From: Andrew Mooney <AMooney@fairfieldcity.nsw.gov.au>
Sent: Wednesday, 18 October 2017 2:15 PM
To: Kate Masters
Subject: 24 Davis Road, Wetherill Park - SSD15_7401 - Bettergrow Proposal

As discussed Council's key issues and requested conditions in relation to the Bettergrow are detailed below.

DRAWING TITLE
EROSION AND SEDIMENT CONTROL PLAN

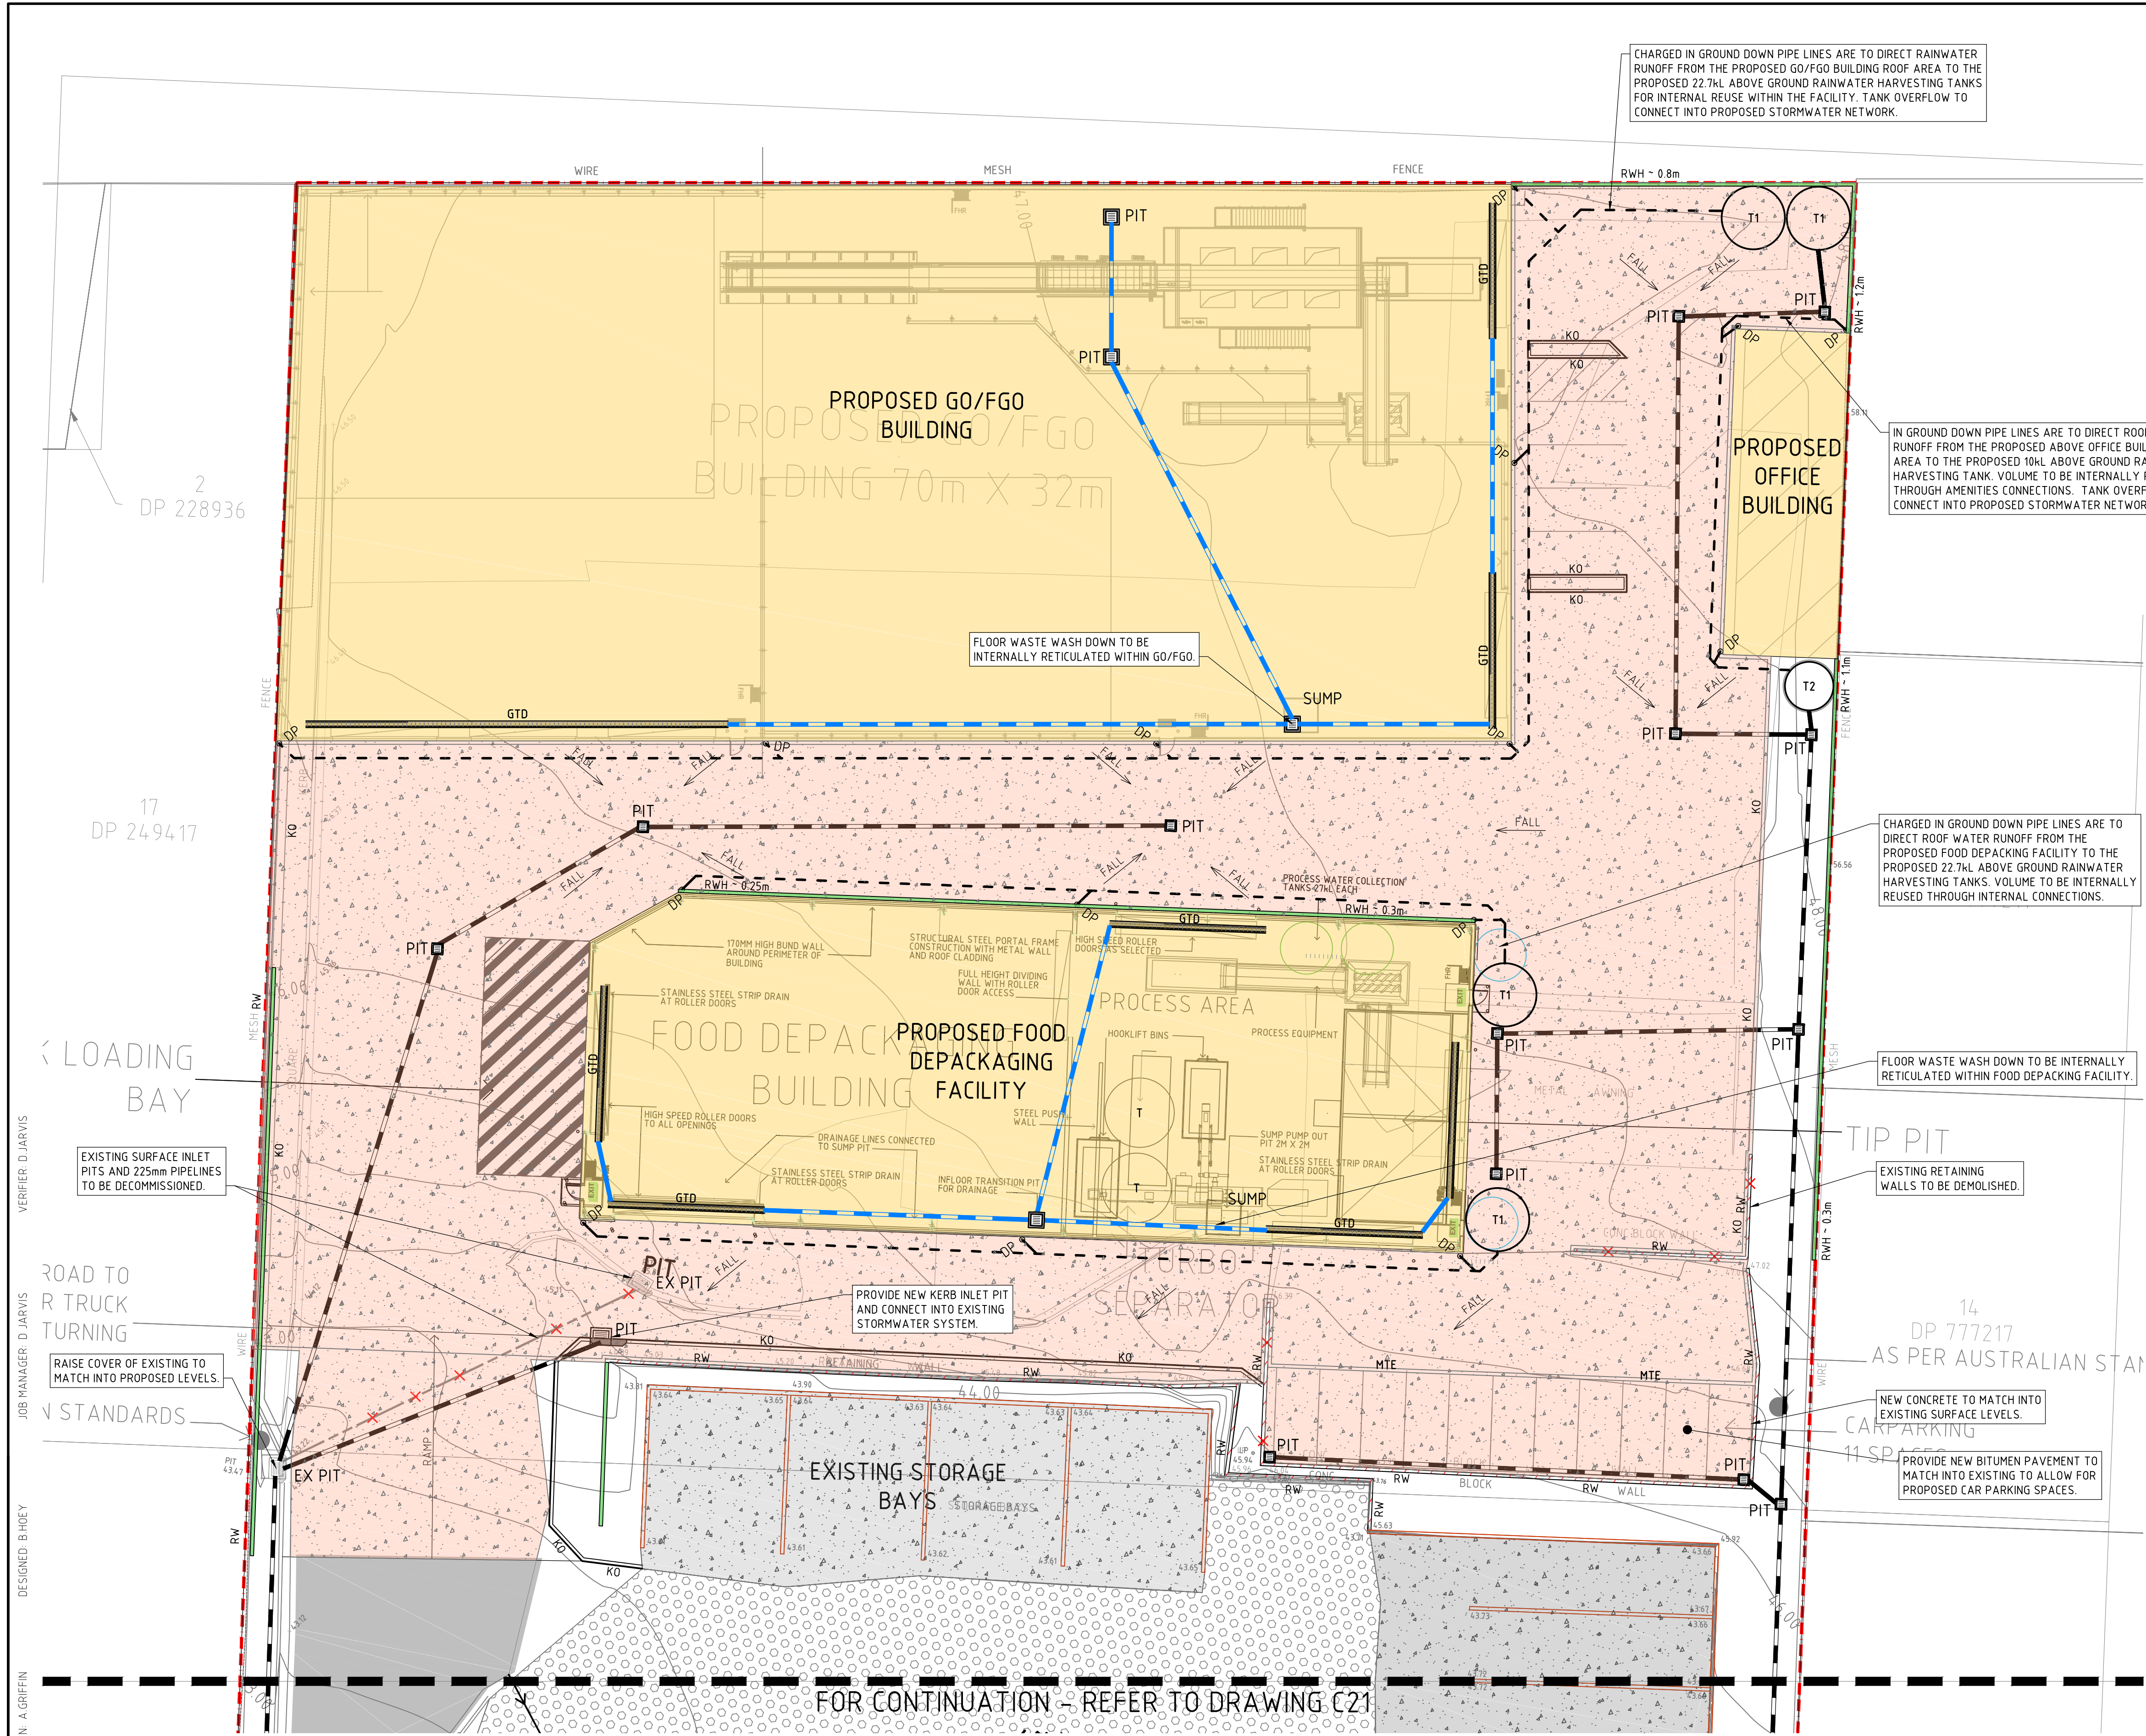
No further proposals for preventing clay sized sediment entering the onsite stormwater system are given.

This is unlikely to be effective without a fully grated wash down area and strict adherence to cleaning and control work practices. The proposed Humeceptor stormwater treatment device is reported to remove particles > 10 microns. Clay particles are < 2 microns. Further details of a wash down area inside the drill mud processing area are required.

- Roofing and bunding for bulk storage is required
- All trafficable areas are to be stabilised via hardstand pavement in either concrete or asphalt. The proposal for a gravel road based is not acceptable to Council.
- Details of any proposals for preventing leachate from organic landscape materials storage areas from entering the onsite stormwater system. This point remains outstanding from previous comments.
- Further details of any proposals for preventing clay sized sediment from drill mud processing areas from entering the onsite stormwater system. Reference should be made to specific proposals to prevent tracking of sediment from this area by vehicles.
